An Bord Pleanála

**Waste to Energy Facility
at Ringskiddy
County Cork**

**Addendum to
Inspector's Report**

04. PA0010

PROPOSED SITE LAYOUT PLAN
(SCALE 1:500 @A0)

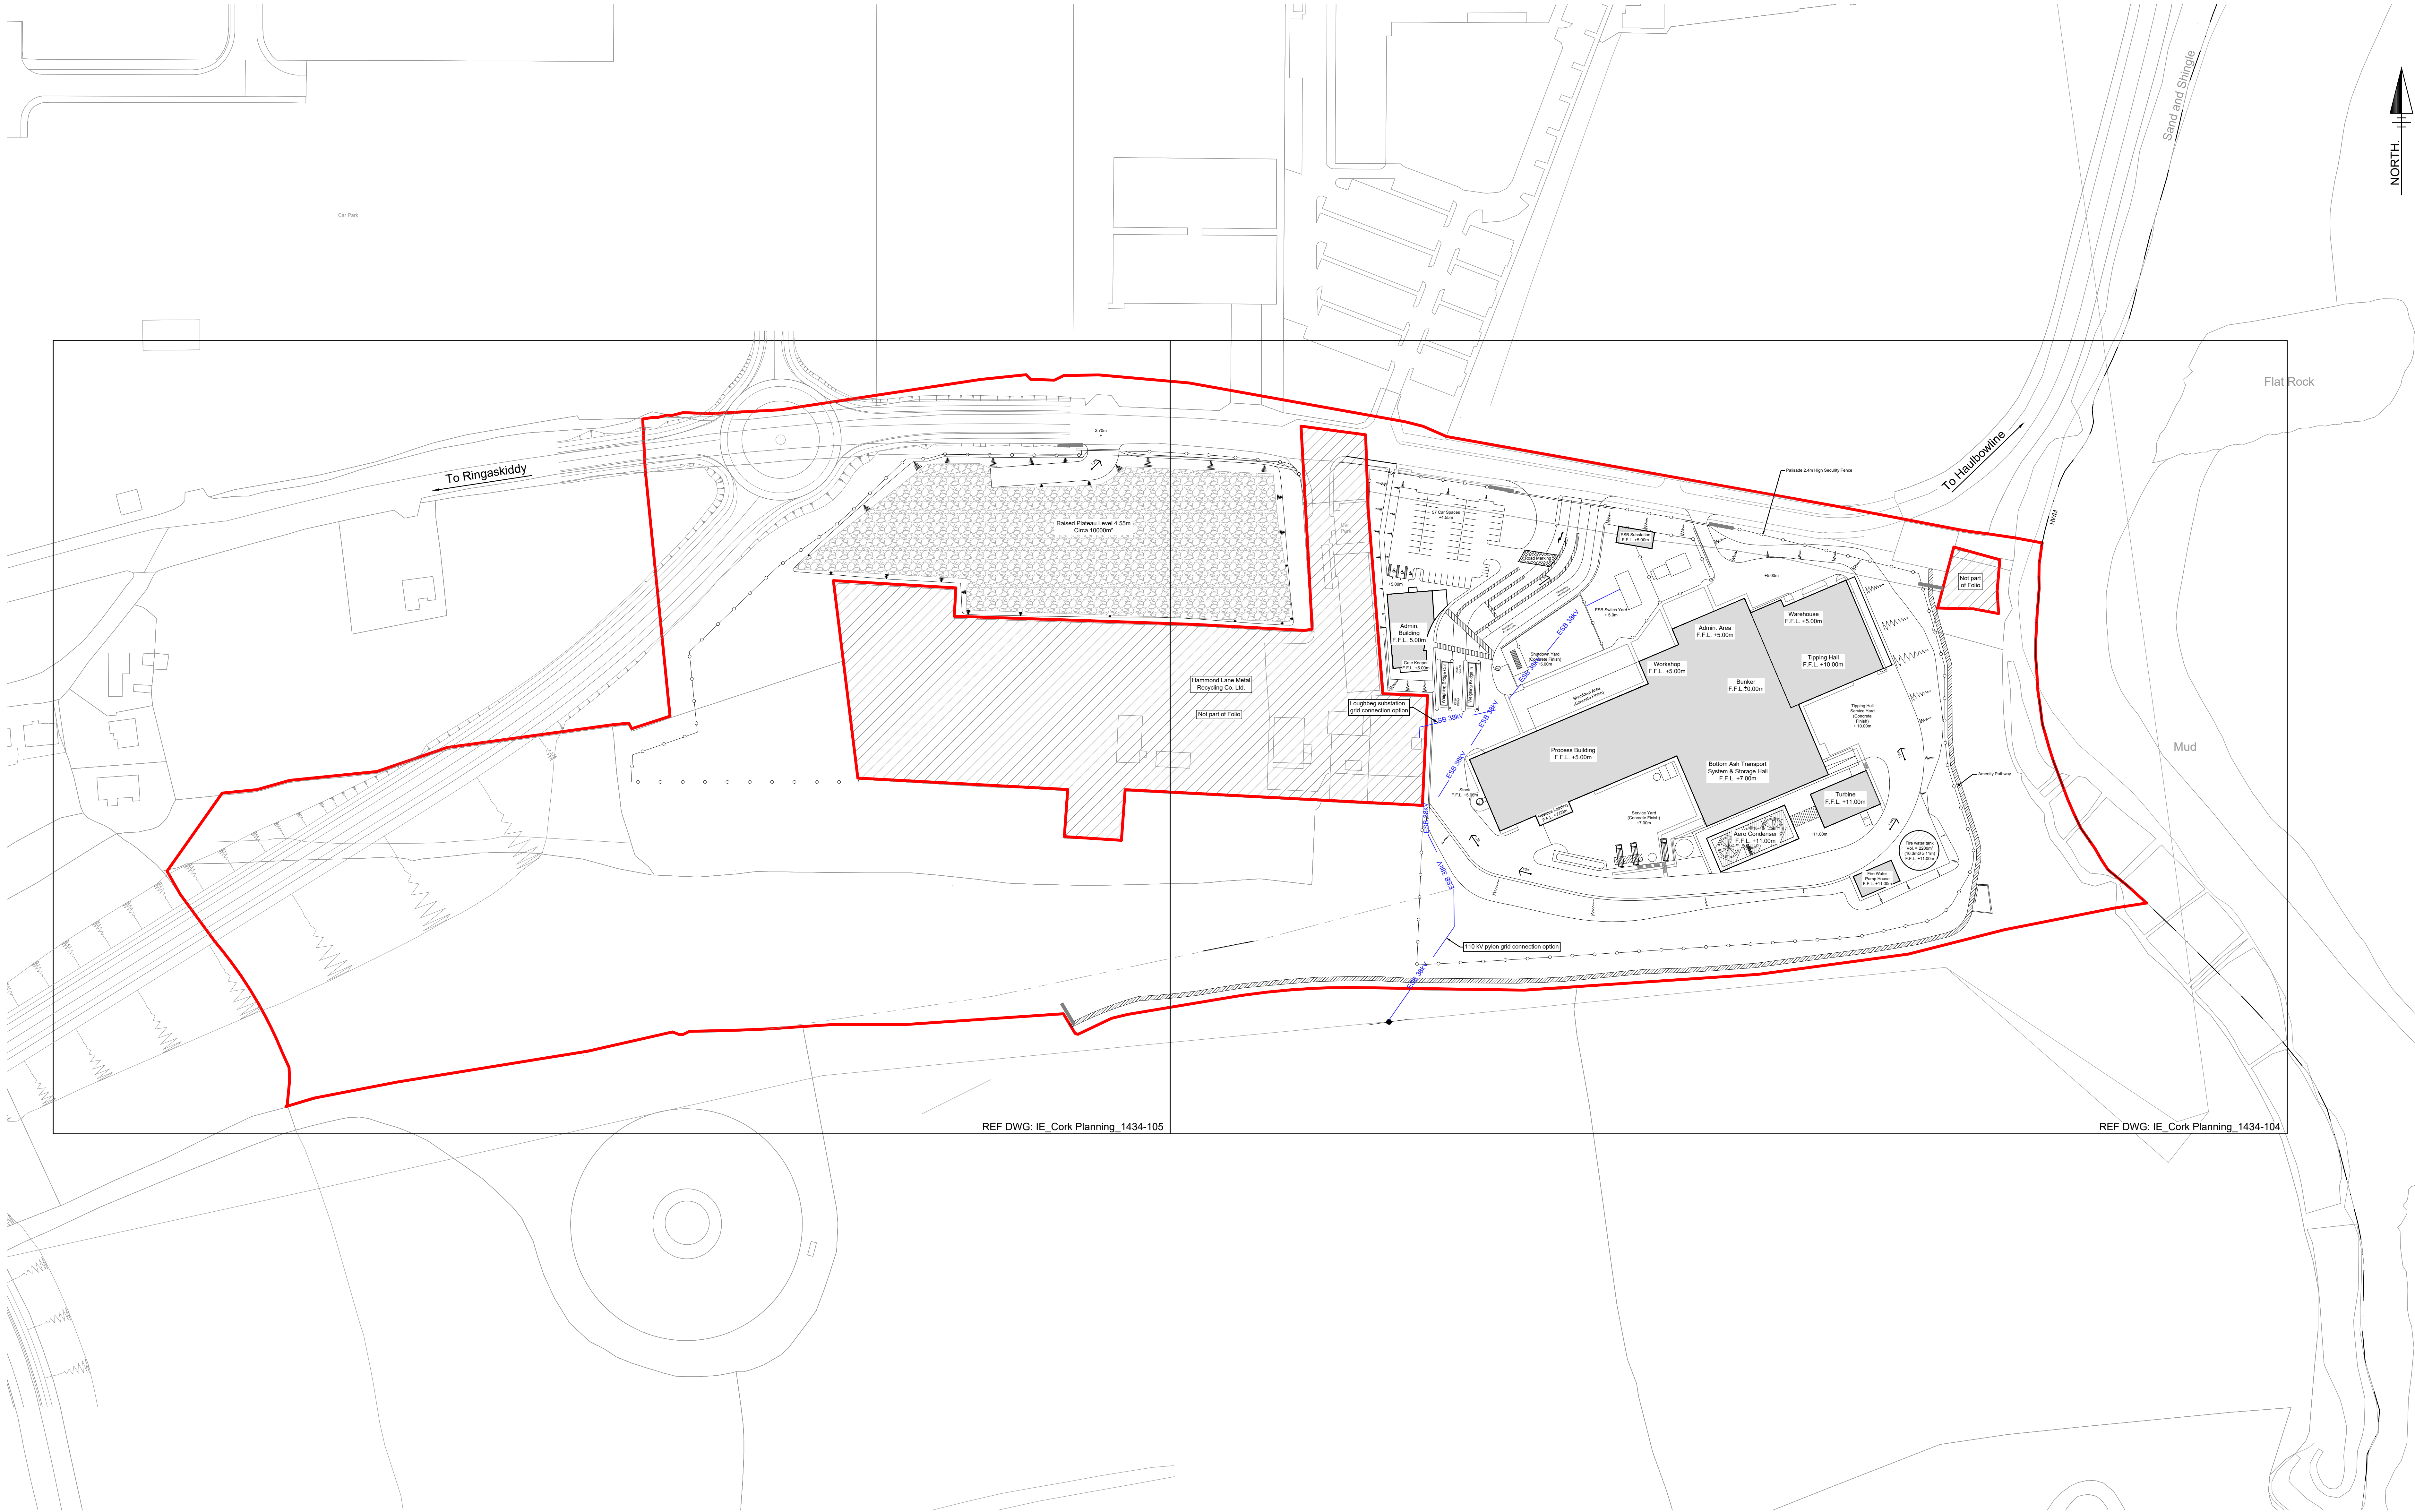
1.3.4 In this case the length of the building is stated to be reduced by 20m, while the stem of the L is stated to be reduced by 10m. I now refer the Board to the site layout plans Drg.no 108040\CD\003 (received Nov 08) and 1030-003 (received Aug, 2010)¹ which indeed indicate that there is an approximately 20m reduction in the overall length of the building (along the road frontage to 170m). There is also some reduction in the width of the stem of the L (approximately 10m). I note however that there seems to be no reduction in the length of the stem, whereby the depth of the building remains at 119m, along the stem of the L.

1.3.5 While I do accept that there is a 9% reduction in the footprint of the revised scheme (mainly arising from 20m reduction of the length), as stated in the EIS, in my view this does not correspond to a reduction which would result from reduction of the capacity from 240,000 tpa to 100,000tpa, through omission of the municipal line (omission of moving grate furnace, reduction of the size of the turbine hall, boiler feed water tank, solidified area, ash bunker, etc).

- 1.3.9 In view of the above, it is my considered opinion that while there is some reduction in the scale of the proposed structure, the modified scheme does not represent a level of reduction which would correspond to reduction of the processing capacity by more than half ‘*to reflect the omission of the municipal waste element*’ as prescribed in the Board Direction /request for further information.
